From: Sarah Burrow <Sarah.Burrow@arun.gov.uk>
Sent: 15 July 2021 16:28
To: Planning.Responses <Planning.Responses@arun.gov.uk>
Cc: Maria Tomalova <Maria.Tomalova@arun.gov.uk>
Subject: RE: Planning Consultation on: AL/66/21/PL

Engineers Comments Regarding Surface Water Drainage

Application No: AL/66/21/PL
Registered: 1st June 2021
Site Address: Land Rear (South) of Sundown Littleheath Road Aldingbourne BN18 0SR
Grid Reference: 494539 107717

Description of Works: 1 No. 4 bedroom detached dwelling with a detached 3 bay garage (2 open bays and 1 enclosed), associated foul field drain, storm soakaway, new front boundary treatment, roof mounted PV & Ground Source Heat pump System (resubmission following AL/32/19/PL). This site is in CIL Zone 3 and is CIL Liable as new dwelling.

DRAWING TITLE
Proposed Site Plan
(Incl Location Block Plan)

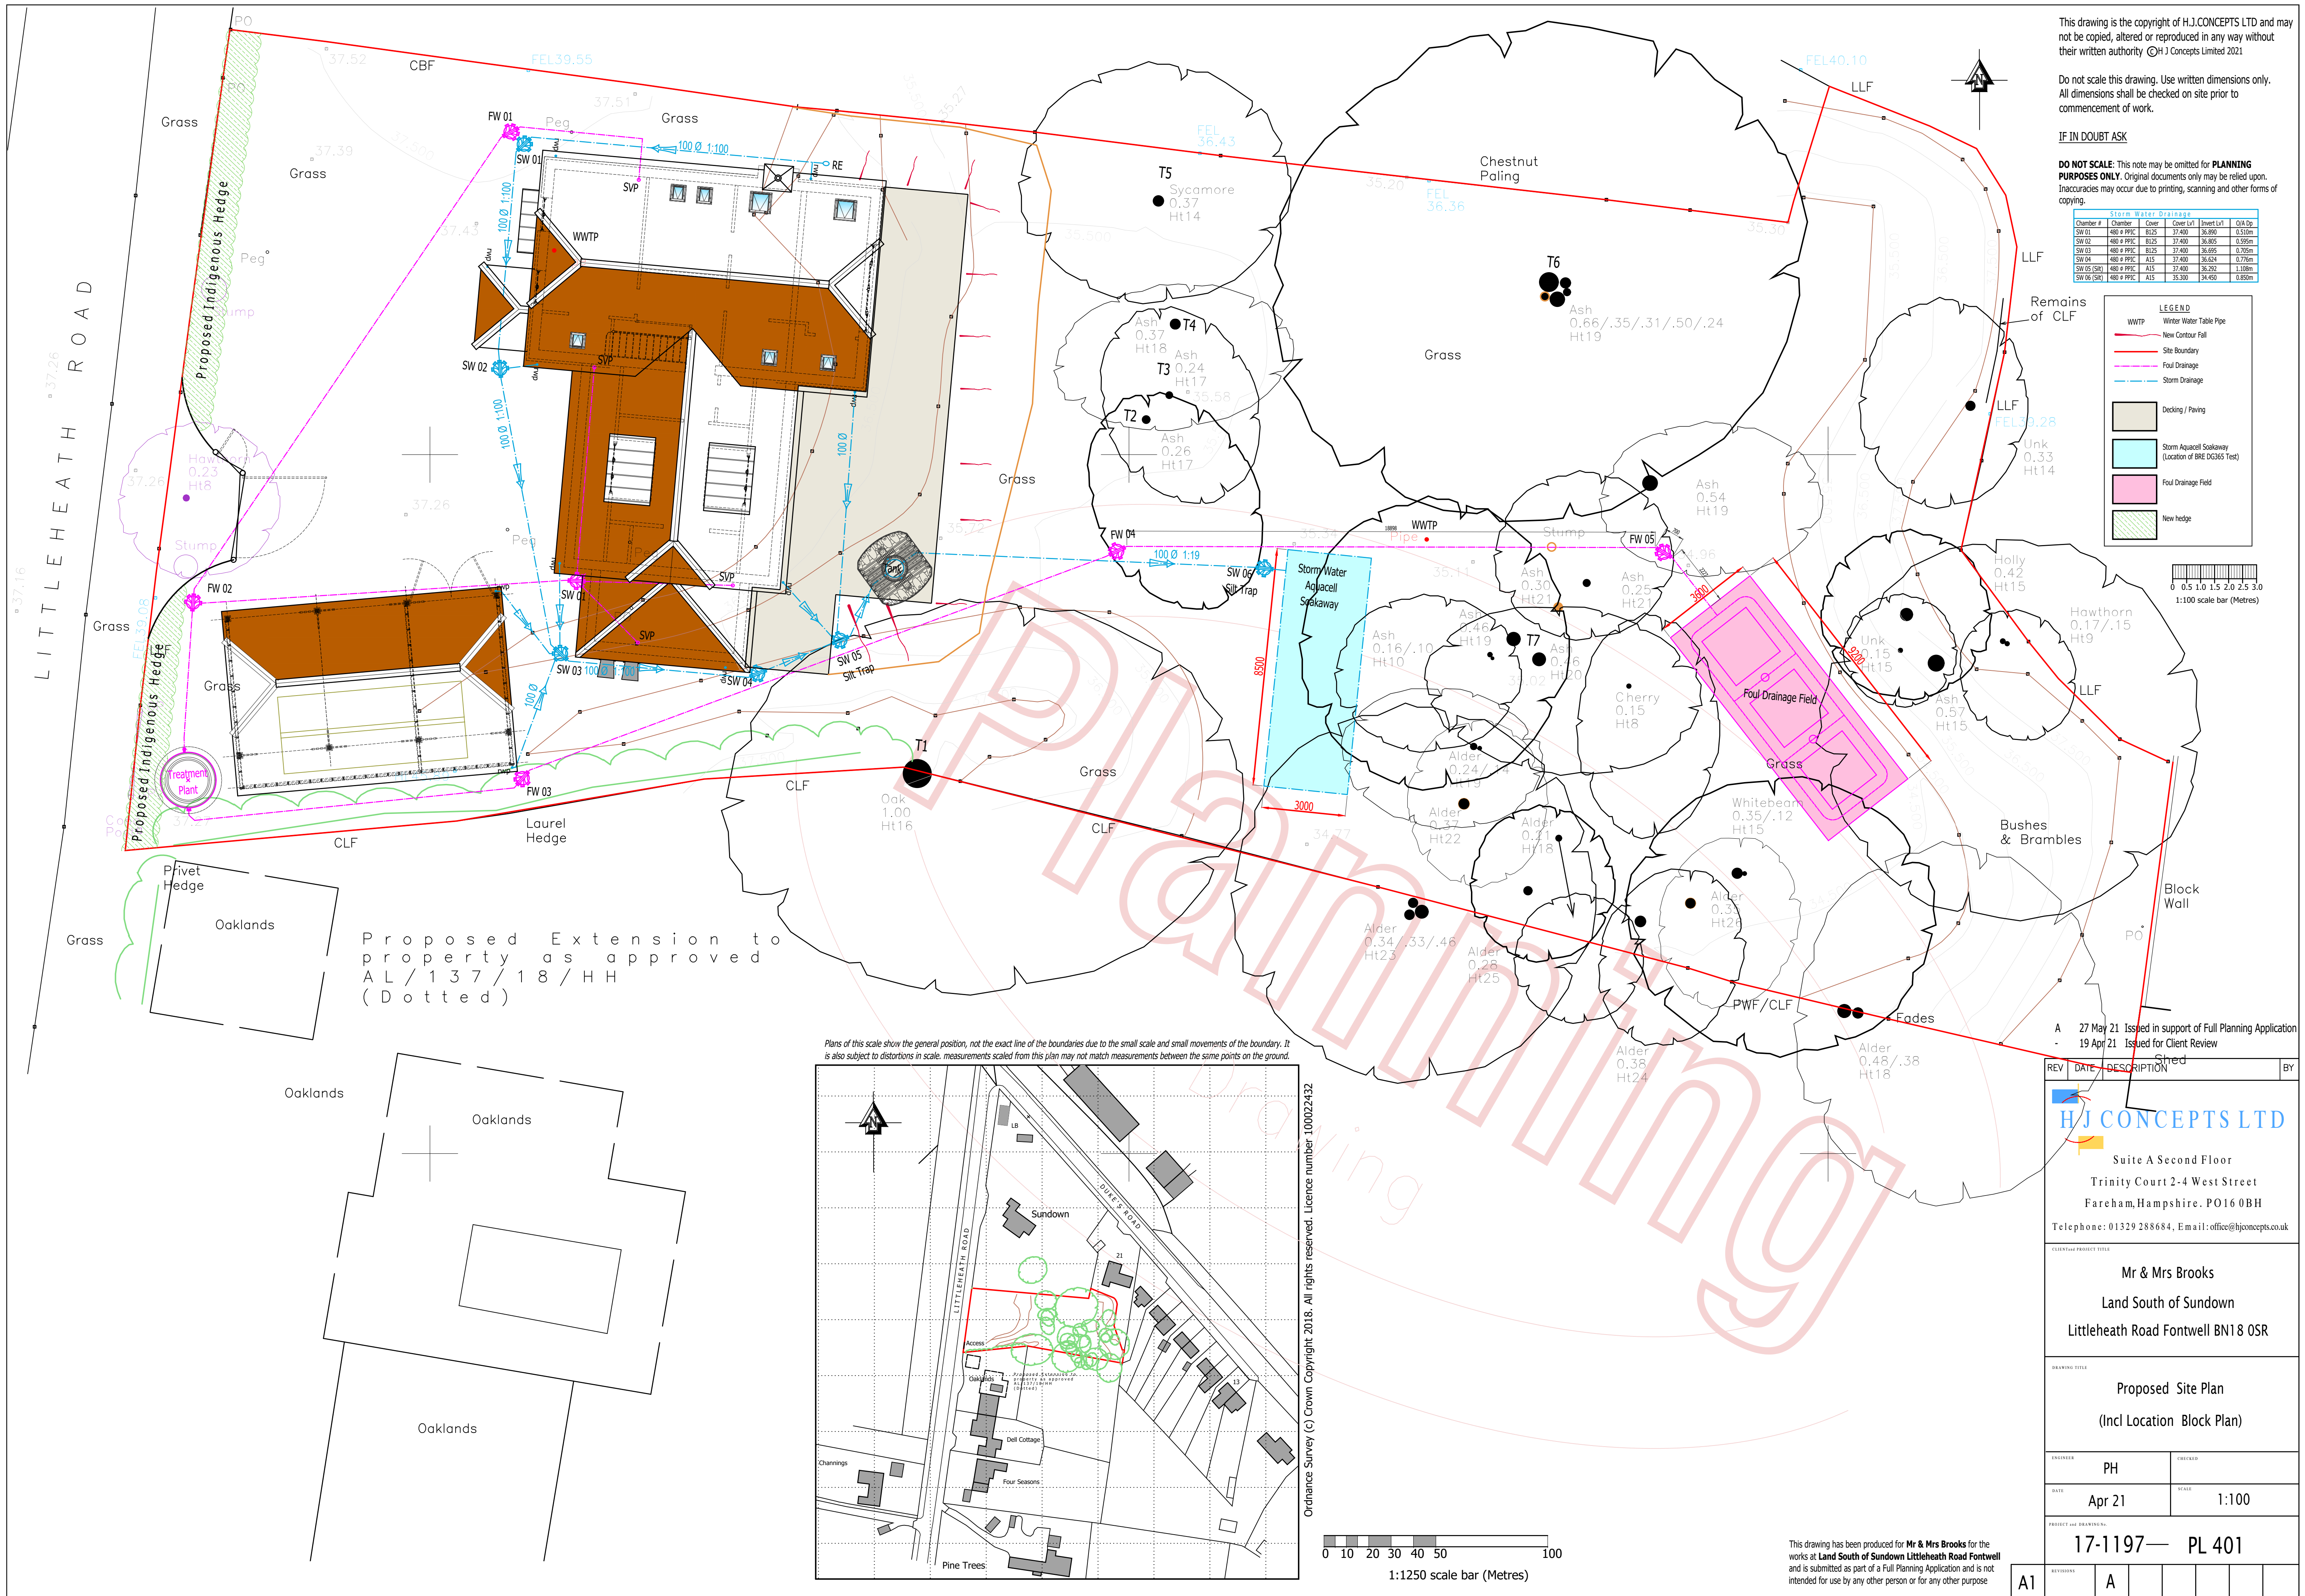
Please consult the Tree Officer for his opinion on the siting of the proposed soakaway (it's proximity to the existing Alder which is being retained offsite) and the proposed measures described in the Arboricultural Addendum to mitigate tree root damage.
